RE: Preferred Project Report - Student Accommodation Blocks 3b, 3c & 10, Central Park, Chippendale (Former Carlton United Brewery Site) (Mp11_0090)

I refer to your correspondence received on 15 October 2012, inviting Council to make a submission on the Preferred Project Report (PPR) for the construction of student accommodation and retail uses on Blocks 3B, 3C and 10 at the abovementioned site.

ELEVATION OF TYPICAL BLOCK 10 INTERNAL PRIVACY LOUVRE

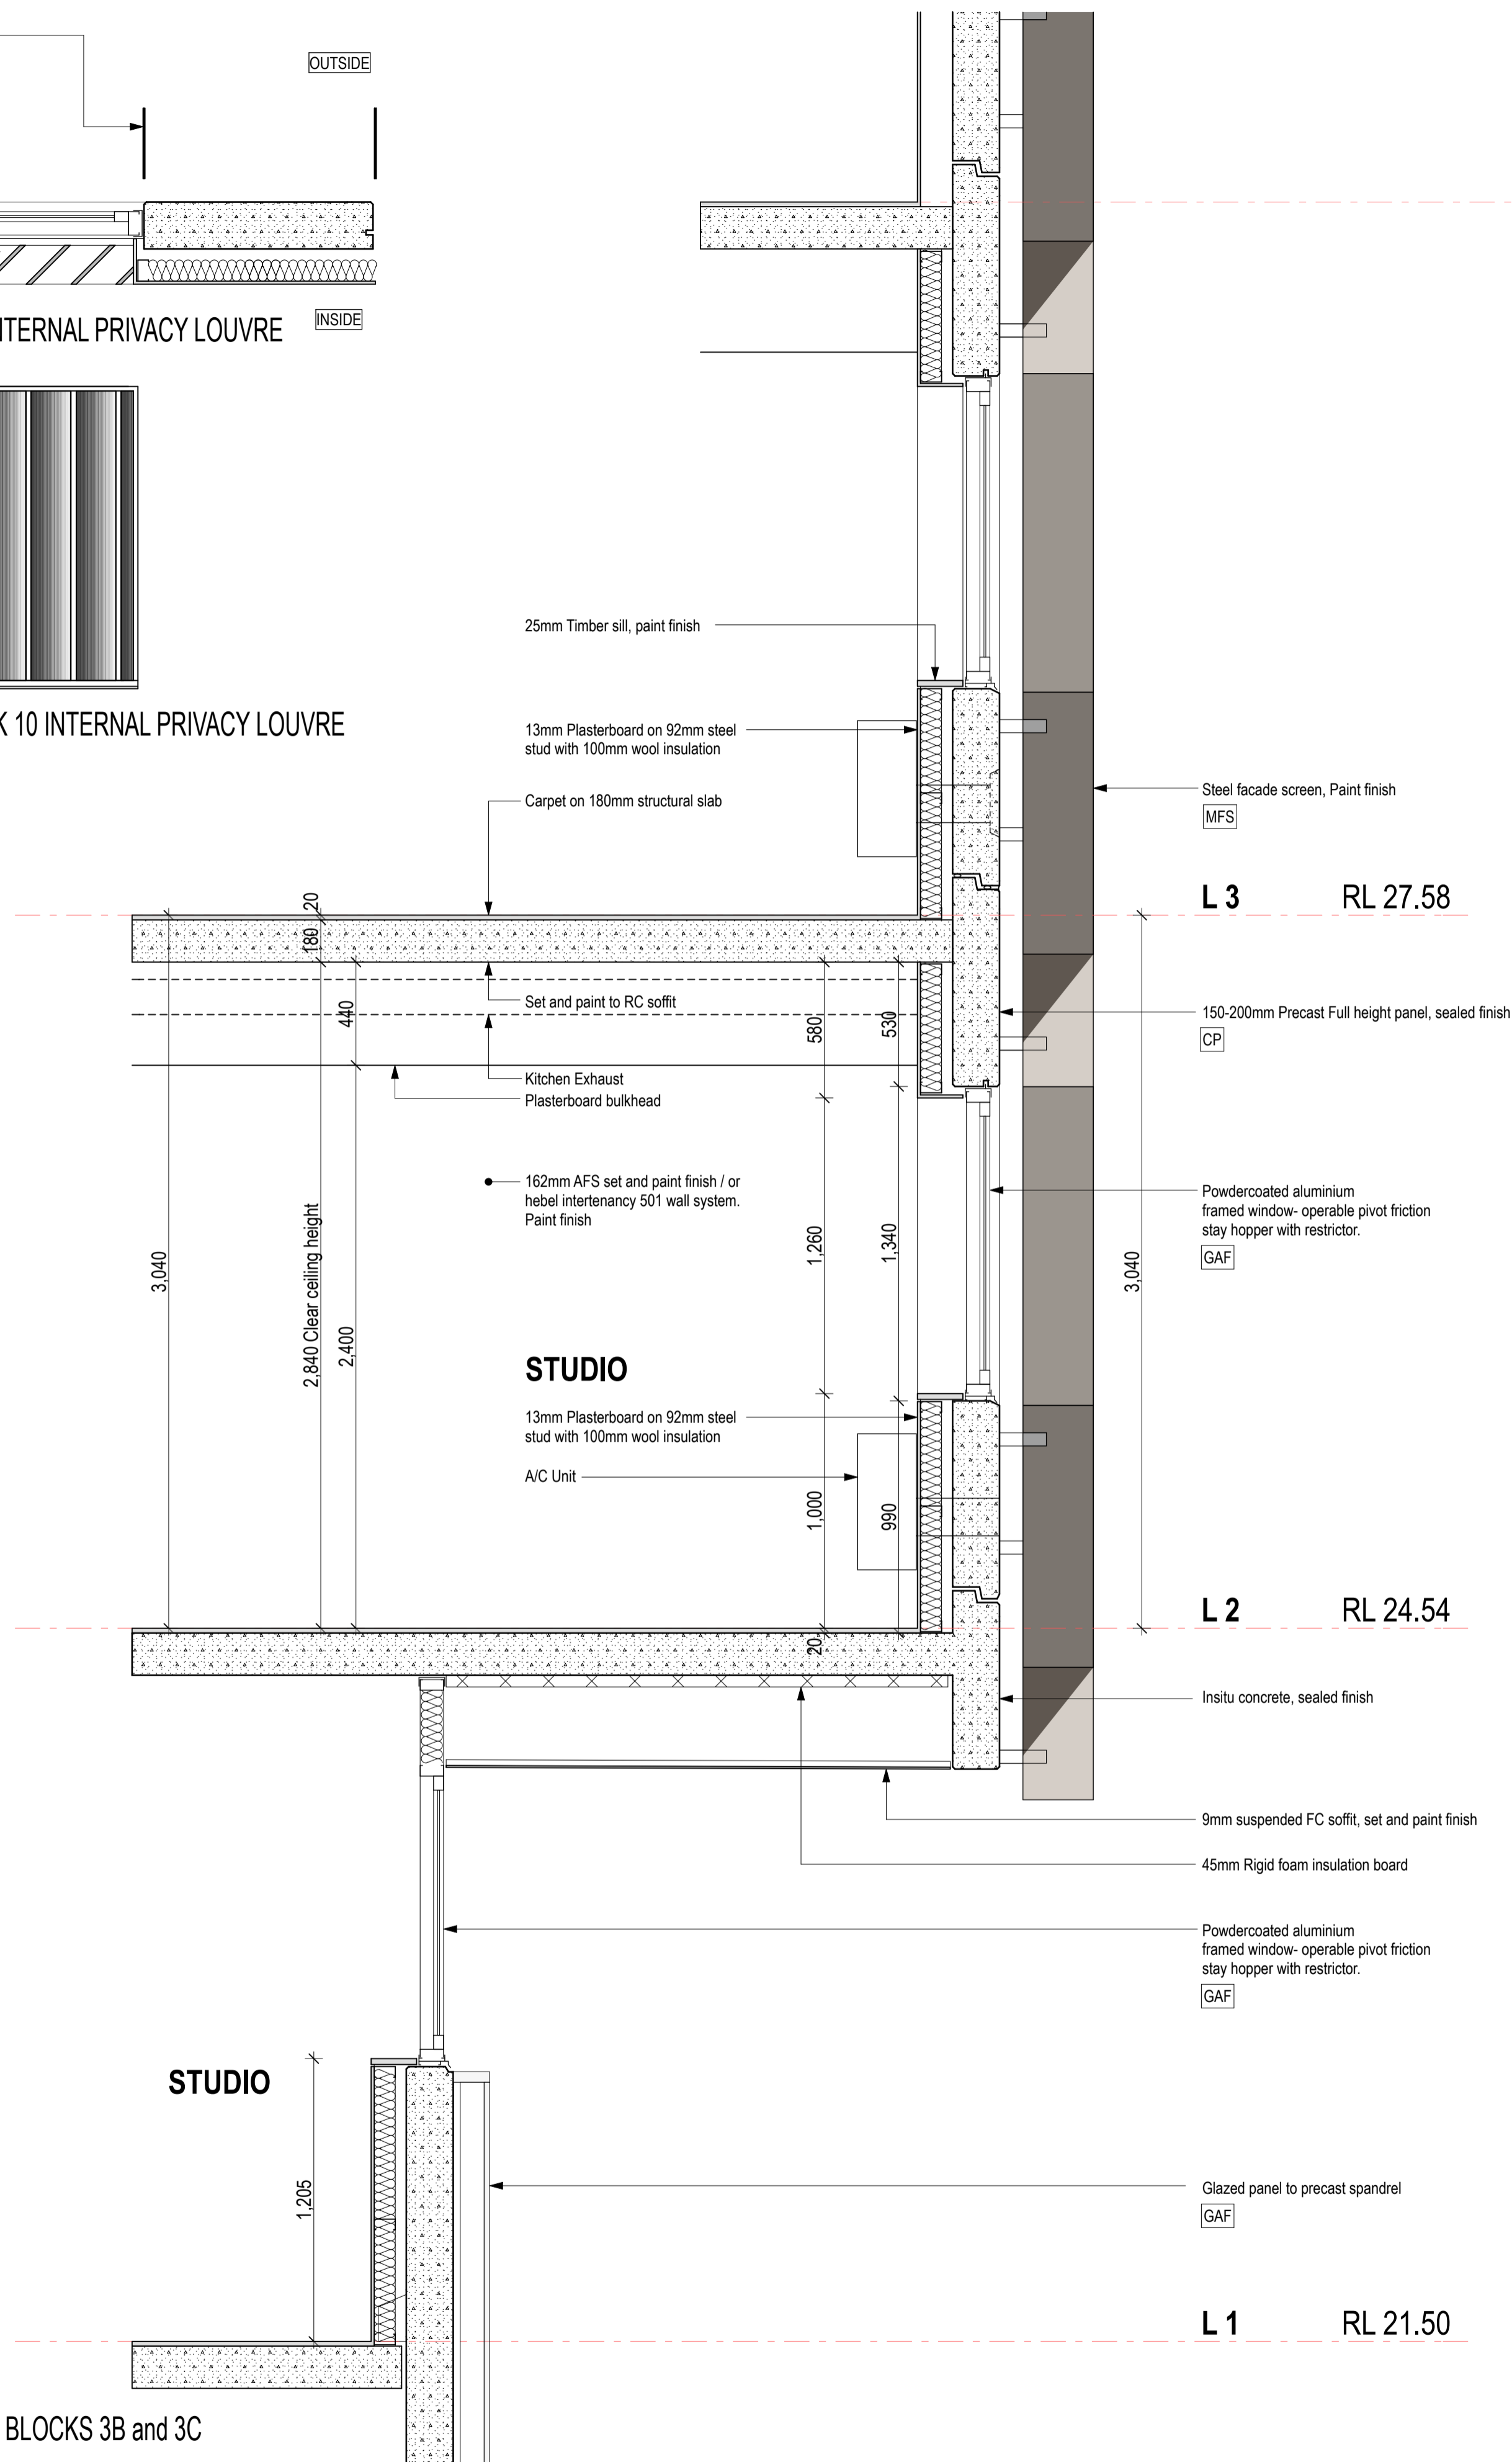
- Enlarge window openings on the northern elevation of 4 bedroom cluster unit on Level 1;
- Removal of internally fixed louvres to east and west facing windows on Levels and replace with venetian blinds; and
- New openings to the northern and western elevation of the common area on Level 2.
